RBA Response 6-12-2024

**Re: Eagle Ranch Retail**  
**9641 Eagle Ranch Rd NW**  
**Site Plan**  
Architect's Stamp 3-5-24 (B13D002C)

Based upon the information provided in your submittal received 3-5-24, the above referenced plan cannot be approved for Building Permit until the following comments are addressed:

REVISION DATE 06-10-2024
STATE OF NEW MEXICO RICHARD P. BENNETT No. 1240 3/5/24 REGISTERED ARCHITECT
RBA ARCHITECTURE, PC PLANNING DESIGN 10000 N. 10th Ave. Ste. 202 Albuquerque, NM 87112 www.rbaarch.com
DATE 03-05-2024
SHEET NUMBER AS-1.0

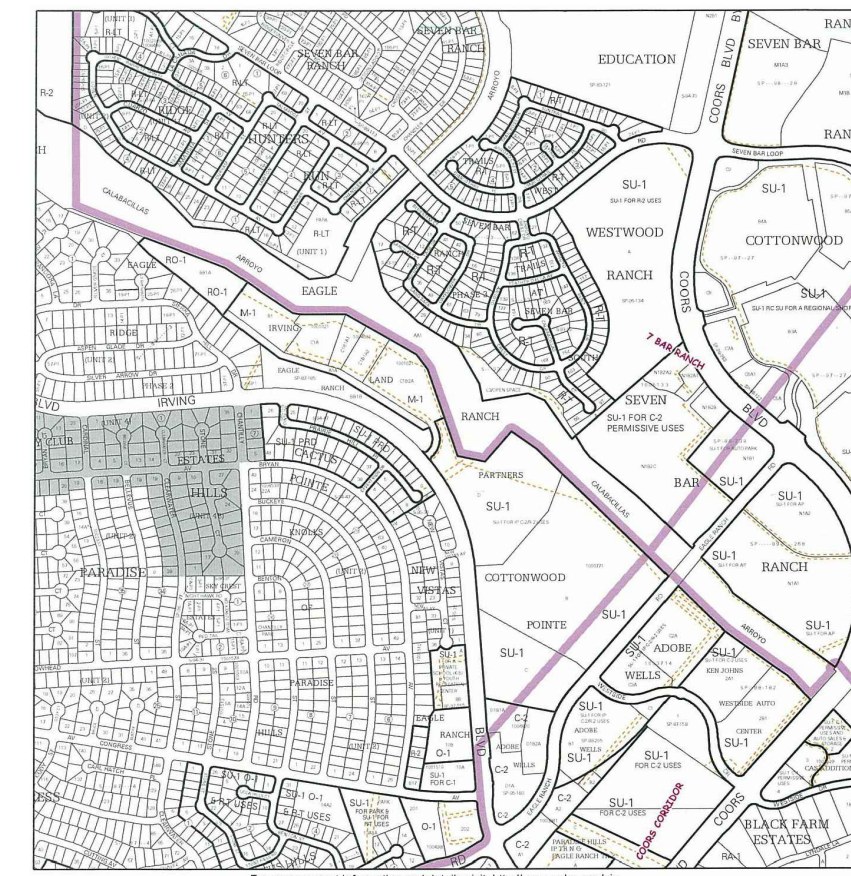
- a. It has two drive lanes at the entry rather than three. **Changed to 2 lanes**
  - b. It does not have signage in the drive lanes. **Added signage**

- c. It shows mini clear sight triangles at the entrance/exits to the project, however, they are drawn in the wrong location. They should be moved south to the back of sidewalk. **Readjusted clear sight triangles**

4. Please revise the Site Plan, AS-1.0, to look more like the Fire One Plan. **Got it as close as I could. Current site plan is approved AA submittal.**

6. Provide a detectable warning surface on the ramp on Eagle Ranch Rd. **Added detectable Warning Surface.**
7. Drive Thru lanes are a minimum of 12 feet wide with a minimum radius (inside) of 25". This radius may be reduced to 15' if the drive thru lane is increased to 14' wide. **Since**

9. Show the streetlight in the Eagle Ranch Rd ROW. Shown on site, see keyed note 40.
10. Parking lot grades should not exceed 8% and major circulation aisles should not exceed 5%. Added to key note 3.

14. Change the ramp at the NW corner, on the west side of the entrance, to be a parallel ramp, rather than a corner ramp as the pedestrian path is only east-west. Ramp has been updated to a parallel ramp.

15. Keyed Note 6. The Accessible aisle is to be striped blue, rather than white. Key note 6 has been edited.
16. A few keyed notes state "per City of Albuquerque standards" or "per CABQ requirements". This is OK if followed by a City Specification: (e.g. 2415A), but not OK if the City Spec is not provided. Revise notes to only contain "Per CABQ ..." if the city Specification/drawing is provided, else provide a detail on the detail sheet.

SHEET NUMBER
FIRE-1.0

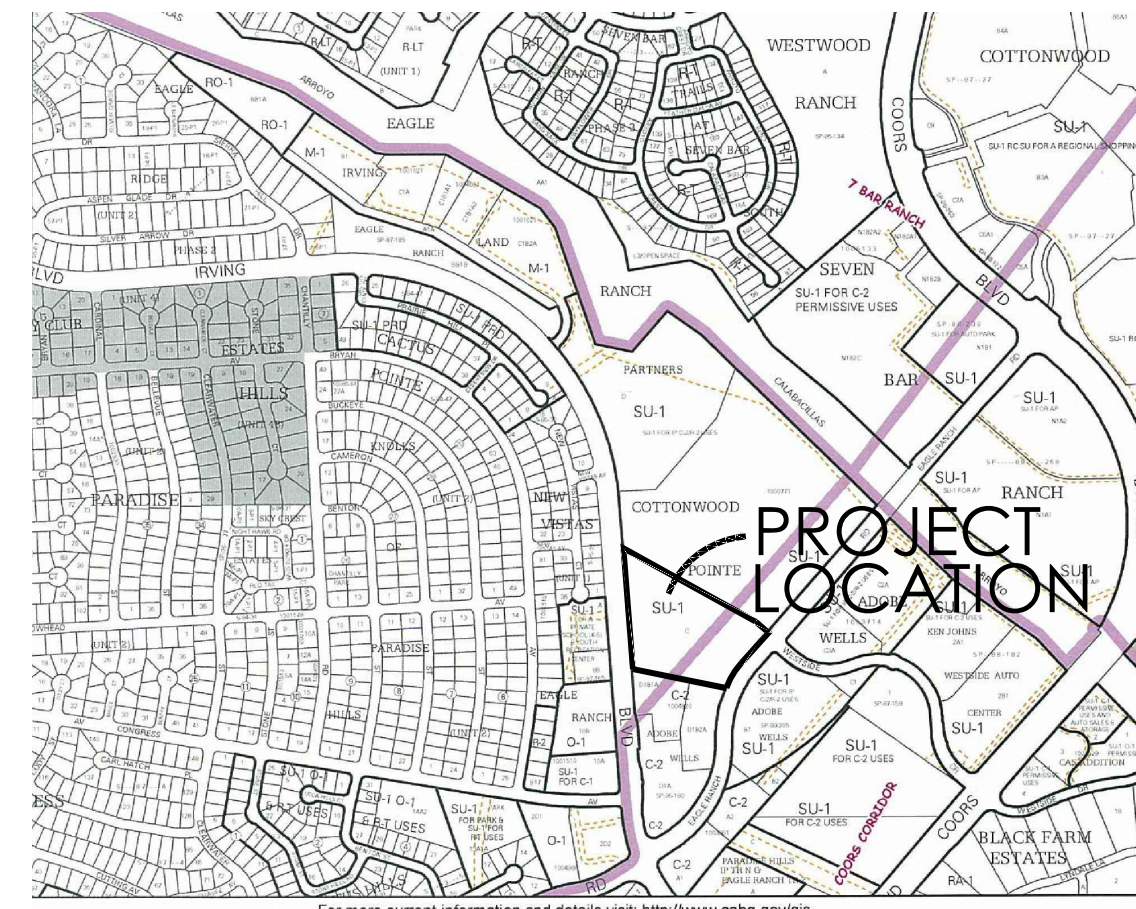
2. Provide Solid Waste approval. **Solid Waste approved temporary dumpster location.**
3. The approved Fire One Plan, sealed 8-4-22, is considerably different than the AS-1.0 Site Plan, sealed 3-5-24. I prefer the functionality of the Fire One plan to be better.

REVISION	DATE
RBA ARCHITECTURE, PC ARCHITECTURE PLANNING DESIGN 10000 N. 10th Ave. Ste. 200 Albuquerque, NM 87112 www.rba.com	
DATE	03-05-2024
SHEET NUMBER	AS-1.0

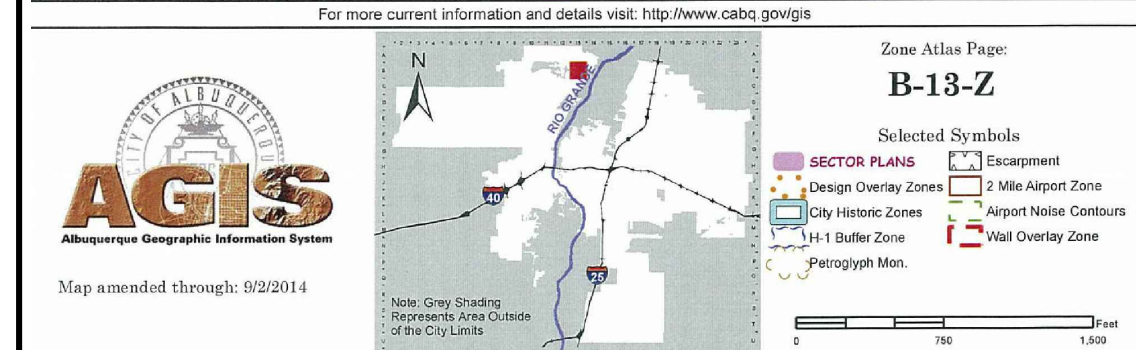
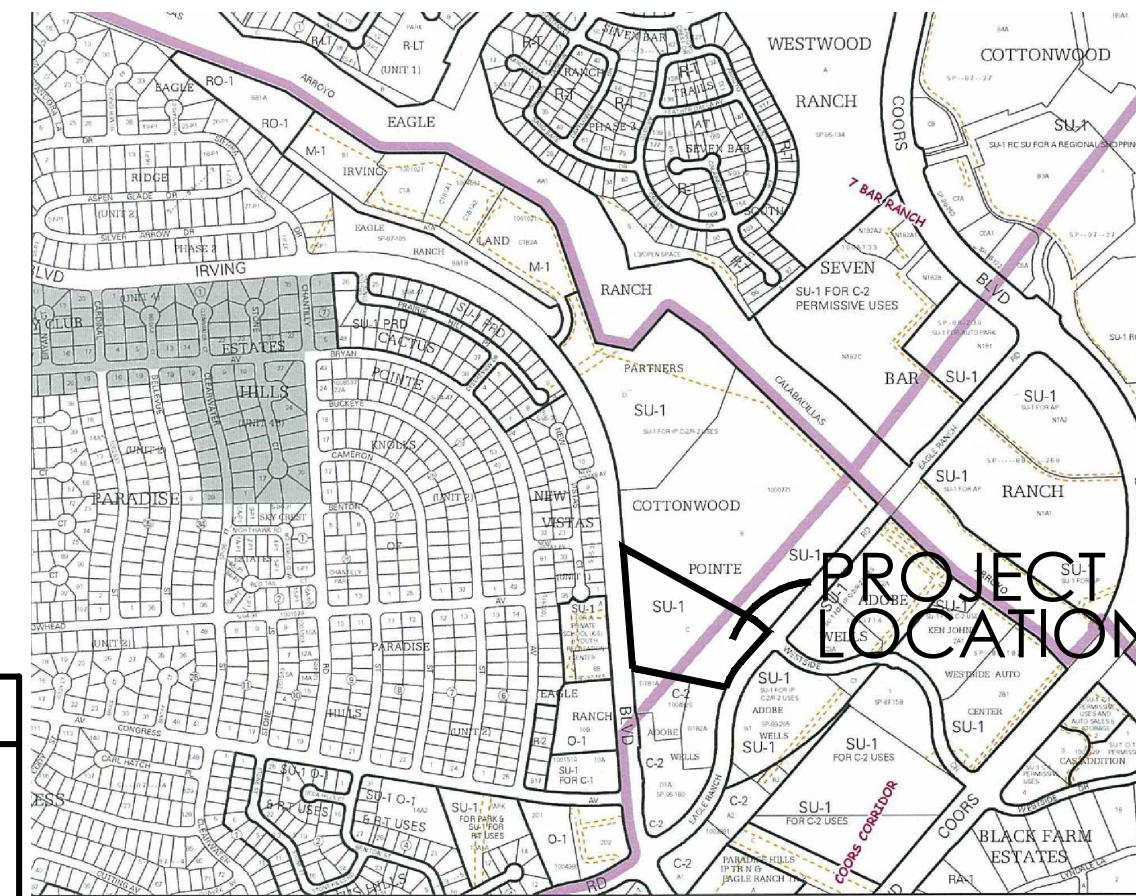
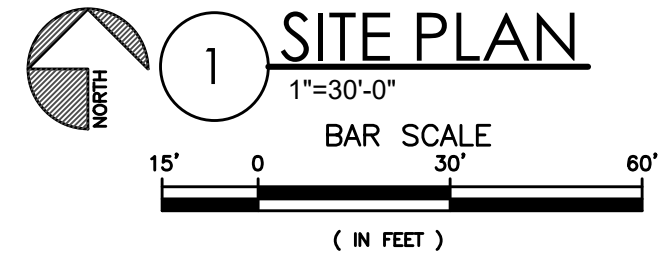
8. Show the vehicle stacking. For Food Service, the minimum is 12 cars at 20' long for each car. Got 12 cars staking for the future building B on site and for Building got 10 spaces on site and two on private drive.

- a. One example is Keyed Note 9: "Accessible parking signage per CABQ standards, REF: Detail A5-AS-2.0". Should be changed to: "Accessible parking signage per REF: Detail A5-AS-2.0" or similar. Edited key notes 5-10 to remover per City CABQ standards.
